SP-24-00013

After reviewing the application for SP-24-00013, Kittitas County Public Health has comments pertaining to the short plat application.

McINTOSH SHORT PLAT PART OF SECTION 8, T. 18 N., R. 18 E., W.M. KITTITAS COUNTY, WASHINGTON

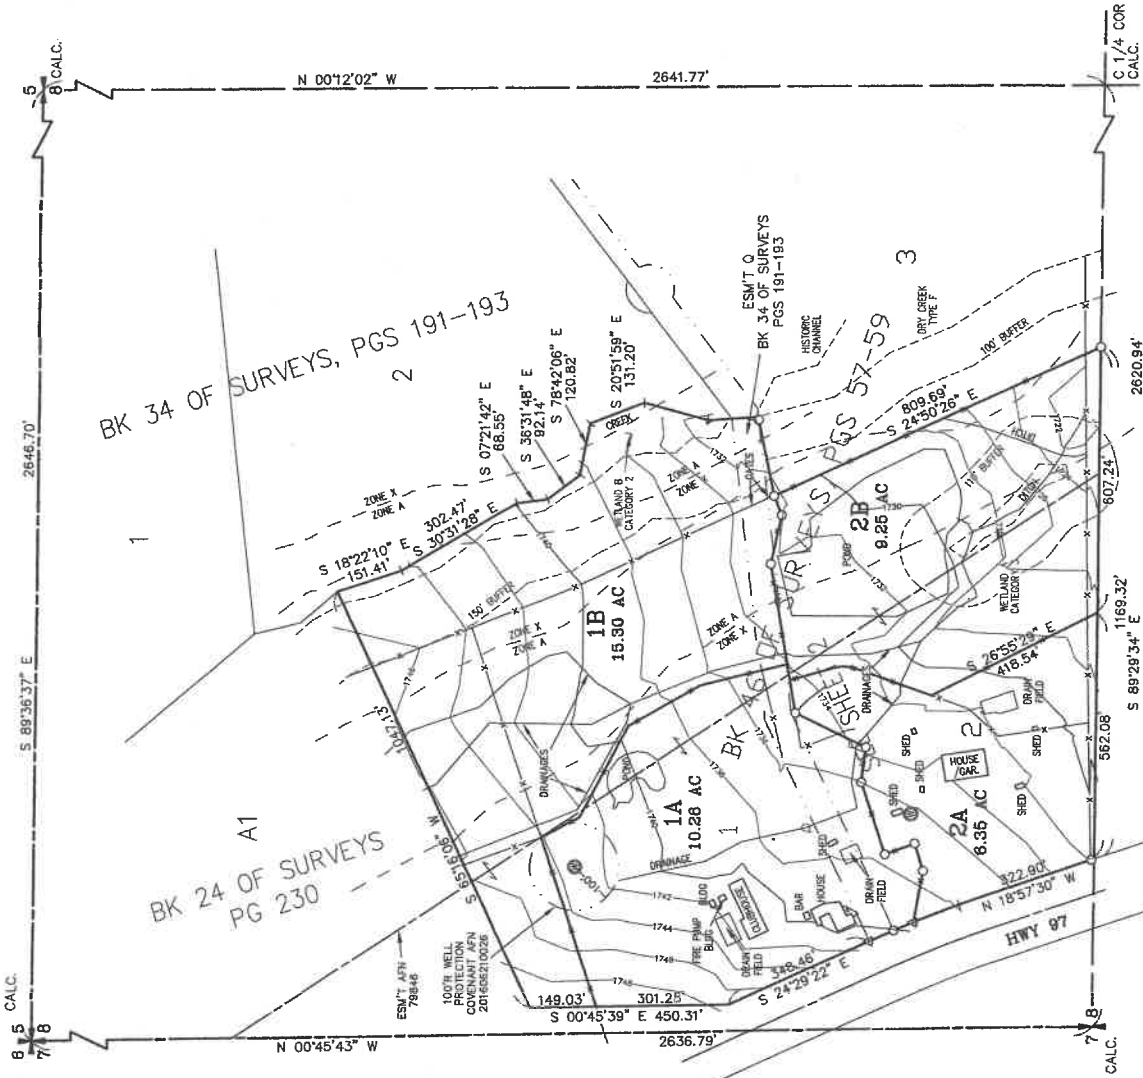
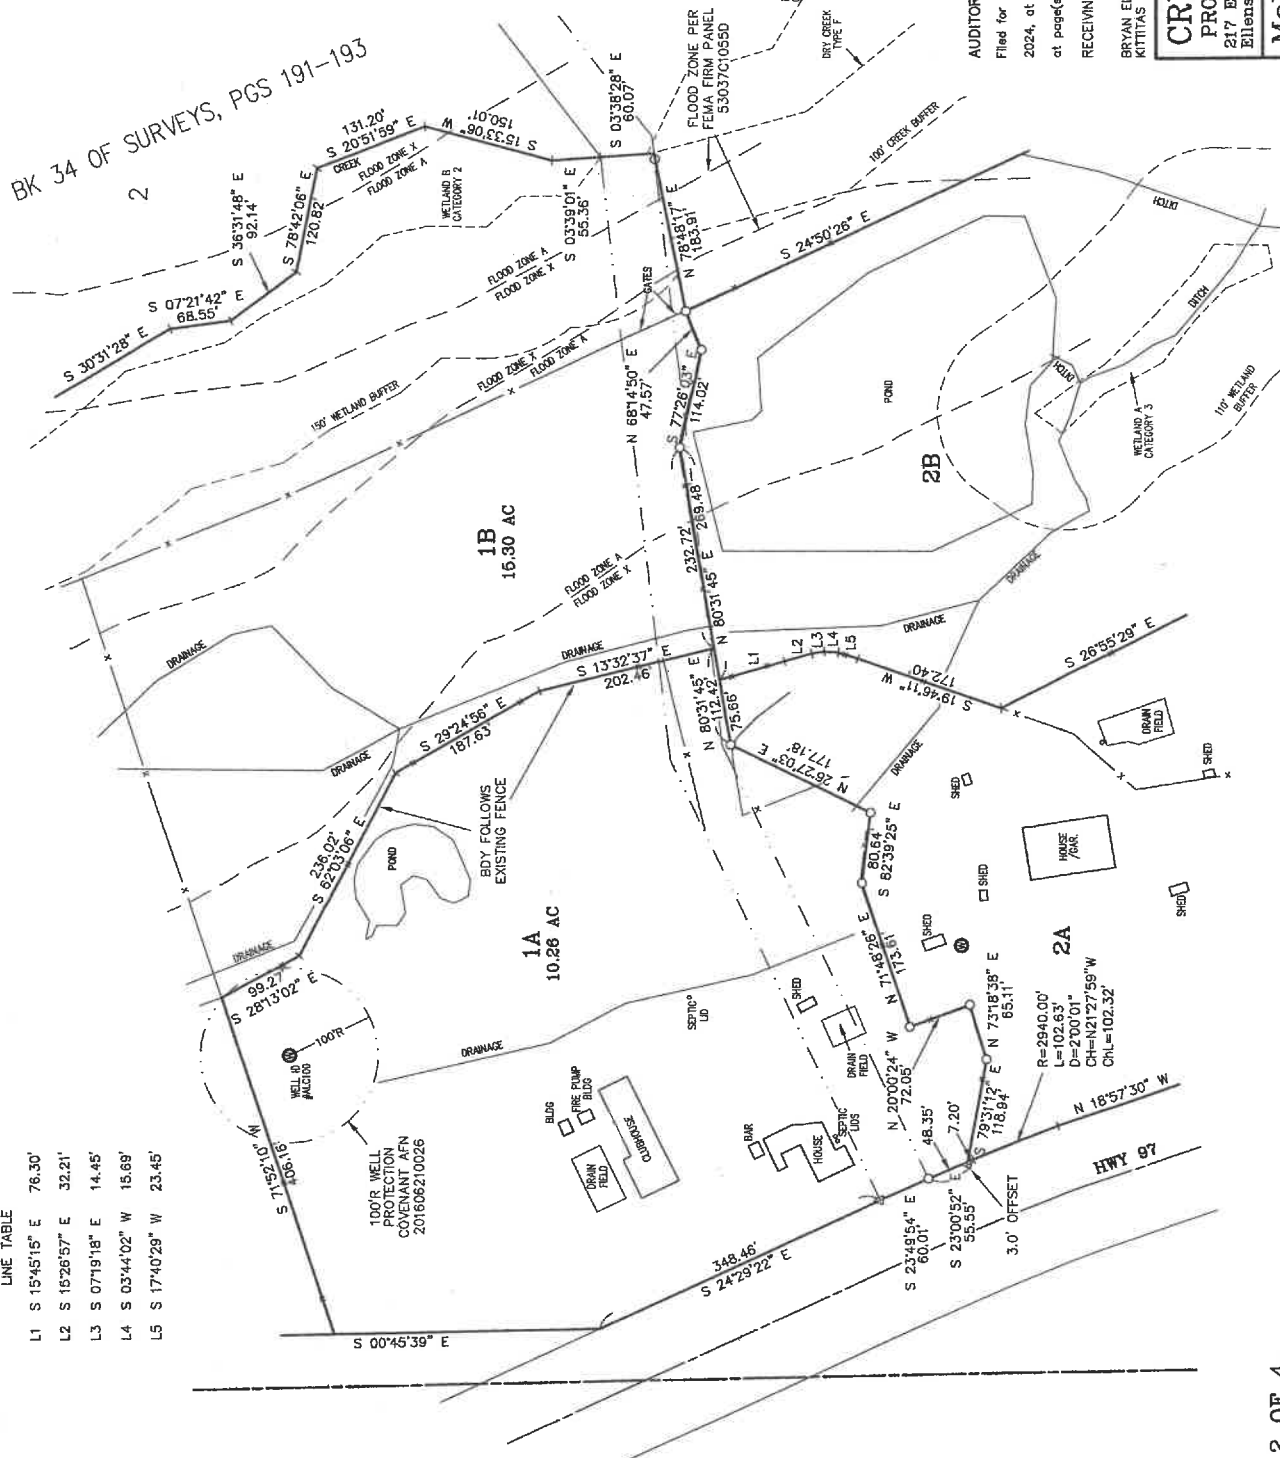
1. Soil logs must be finalized prior to the development of short plats for the locations of 1B and 2B. This will ensure that the soil is suitable for construction.
2. Ensure that the Group A water system has enough connections for the additional two plats.
